7th December 2011

First floor extension above lower roof of existing dwelling to form 2 bedrooms.
2 West Close Middleton on Sea

M/91/11□

2 West Close			Mr & Mrs Thomas		
			09	Edition 0	Sheet

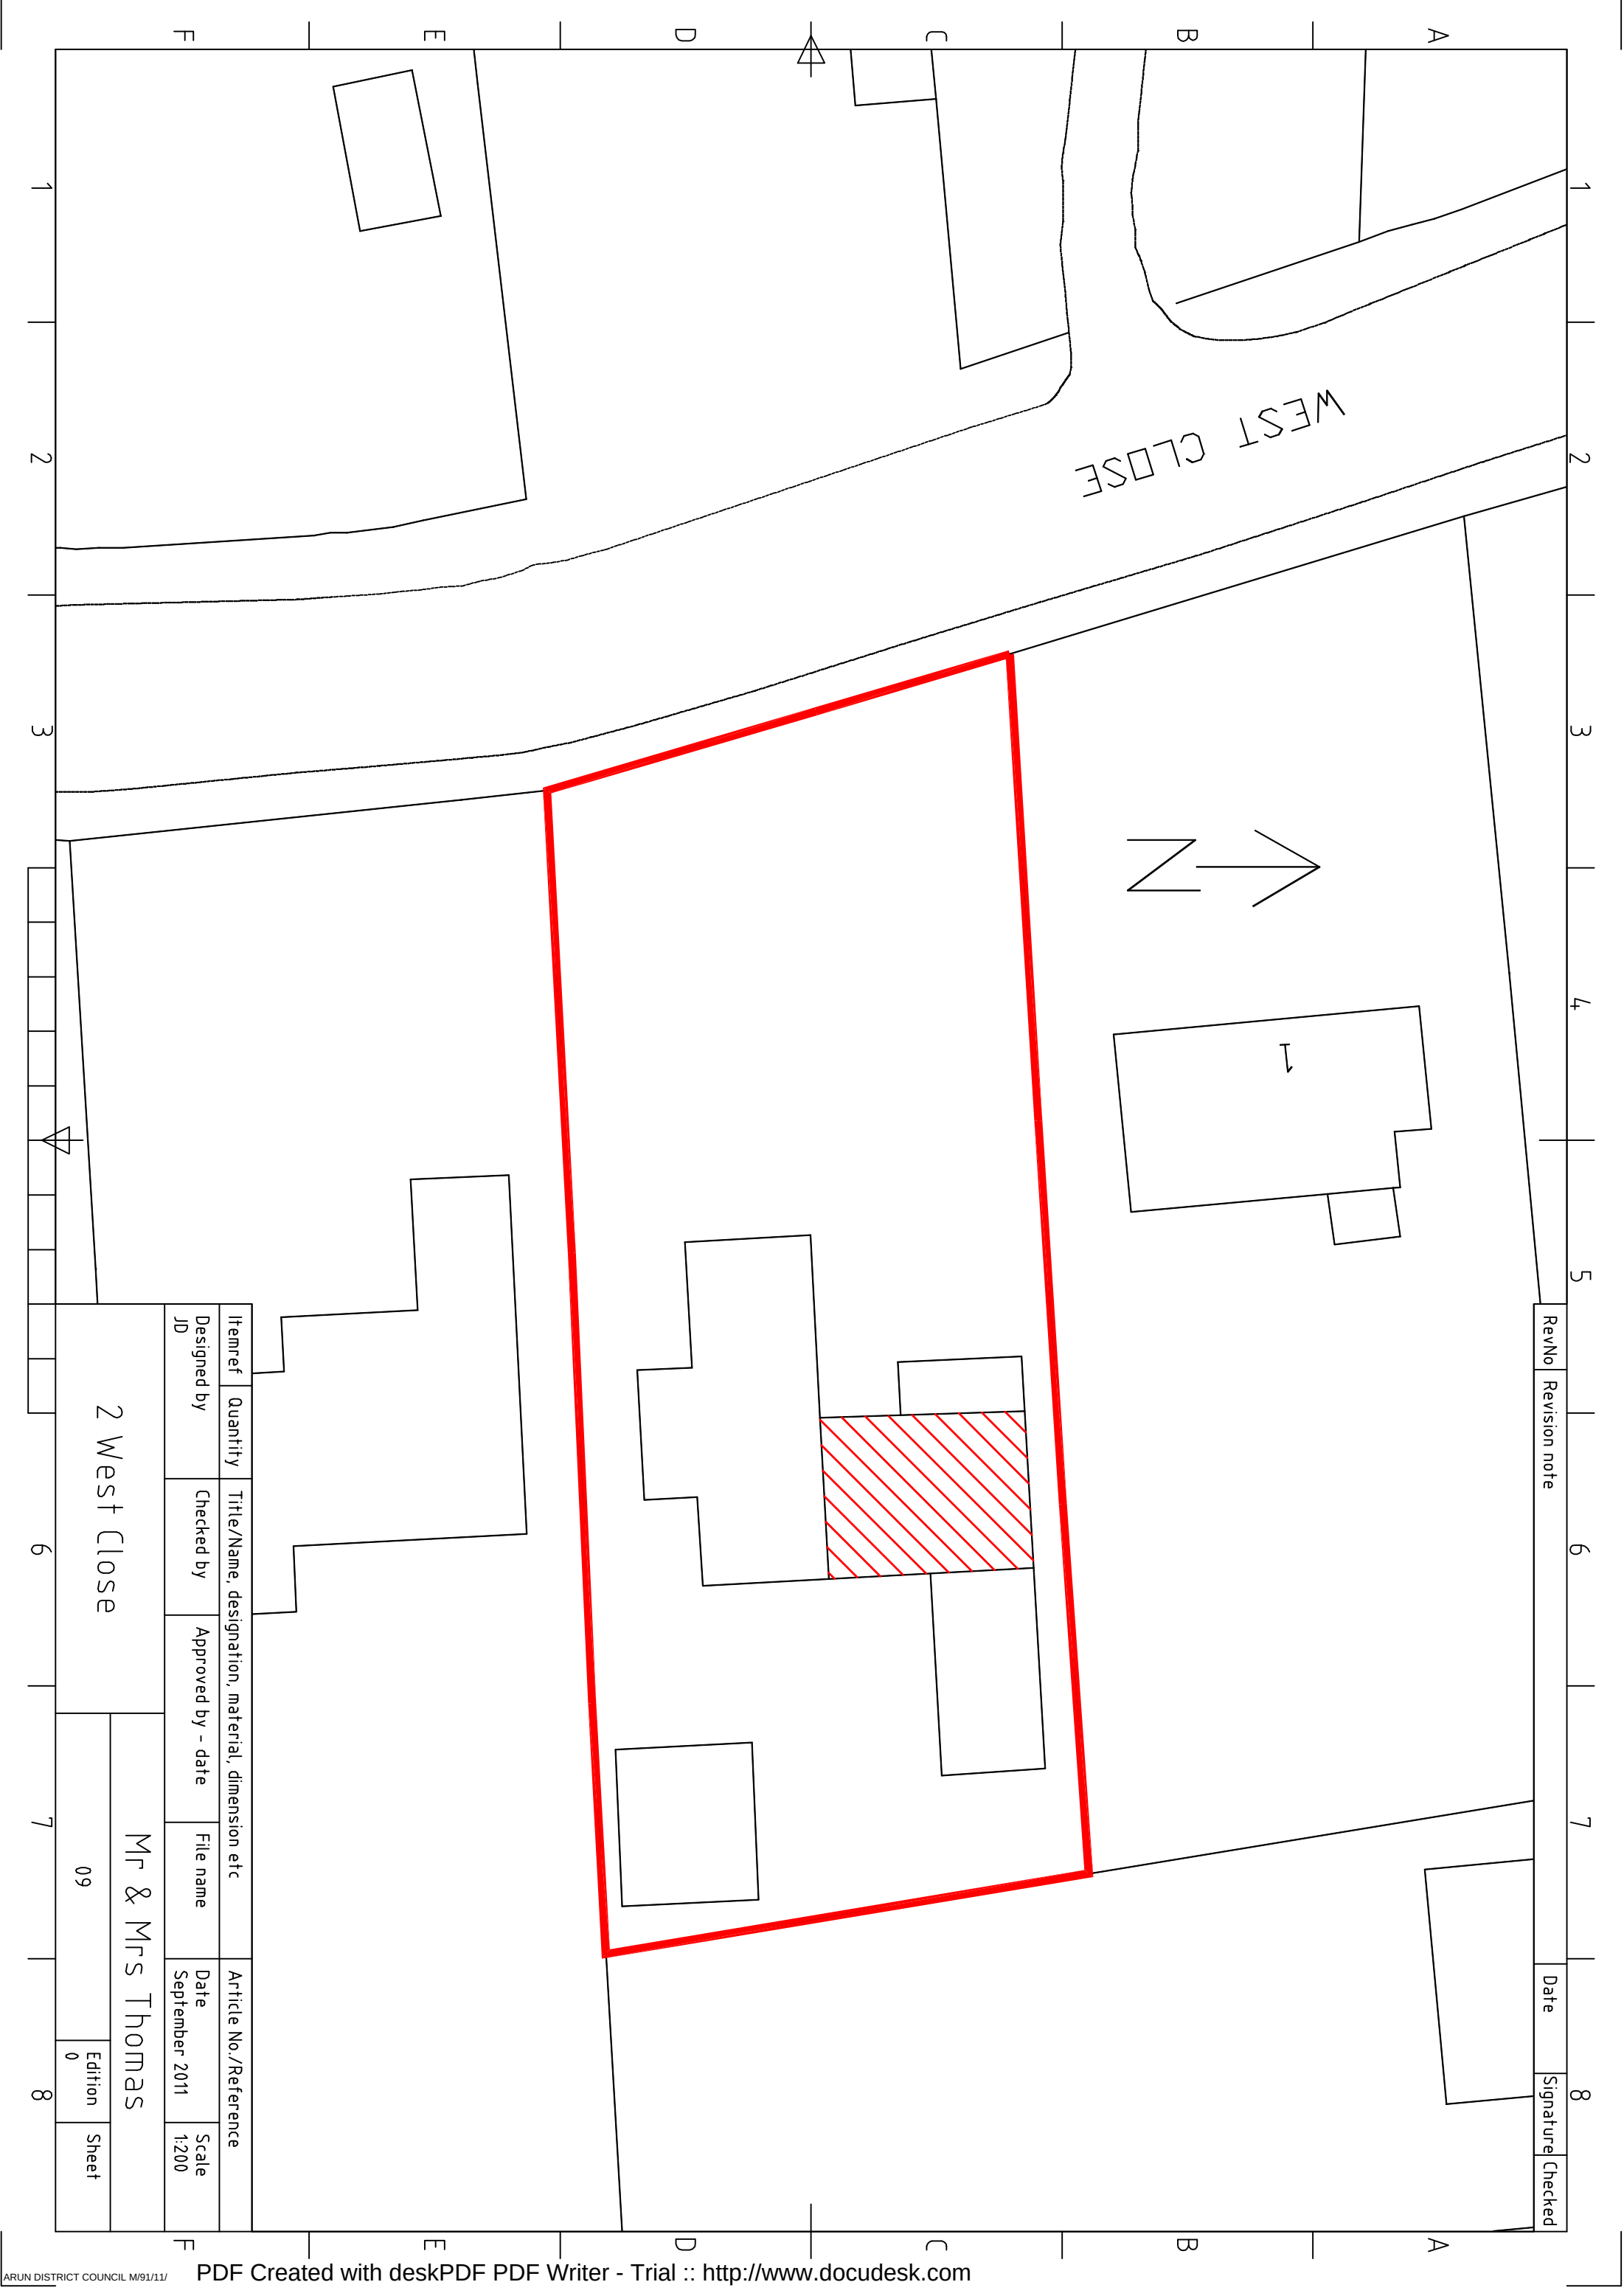
The application shows inaccurate block plans (08 and 09) from over 5 years ago, prior to the extension to 1 West Close (planning application M/76/06). This is misleading as the plans do not accurately represent how the proposed extension will impact on both the ground and first floors of 1 West Close. We recommend a site visit to assess the impact on the neighbouring property to the north. □

The current single storey extension is already very close to the boundary of 1 West Close to the North where fencing and hedging are located. The distances are not accurately represented in the block plans and a site visit is required to assess the impact. □
